Your Ref: OWPC21040
Our Ref: WA/89/18/L 12-10-2018
Please ask for:
Zac Denton

Listed building consent for a replacement 1.19m high privacy screen, affixed to the existing 0.48m high dwarf wall giving a total height of 1.81m to North and West sides of patio.

9 Walberton Park Walberton

Drawing / Elevation
of replacement
Privacy Screen
above existing
dwarf Wall

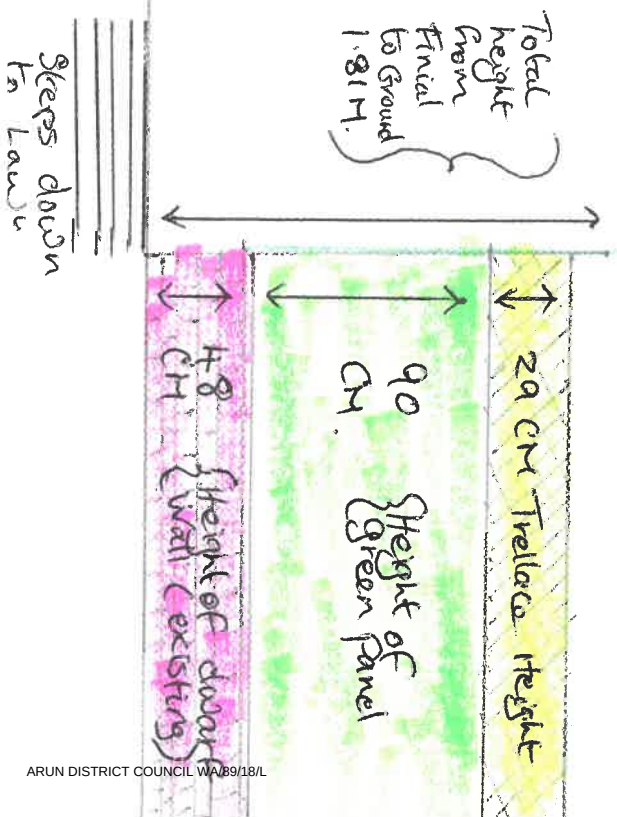
I am a leaseholder at Walberton Park. The green painted metal 'privacy screen' is unsuitable for the top of a patio wall of a listed building of this style. Also, it is taller and more extensive than the wooden fence it purports to replace.
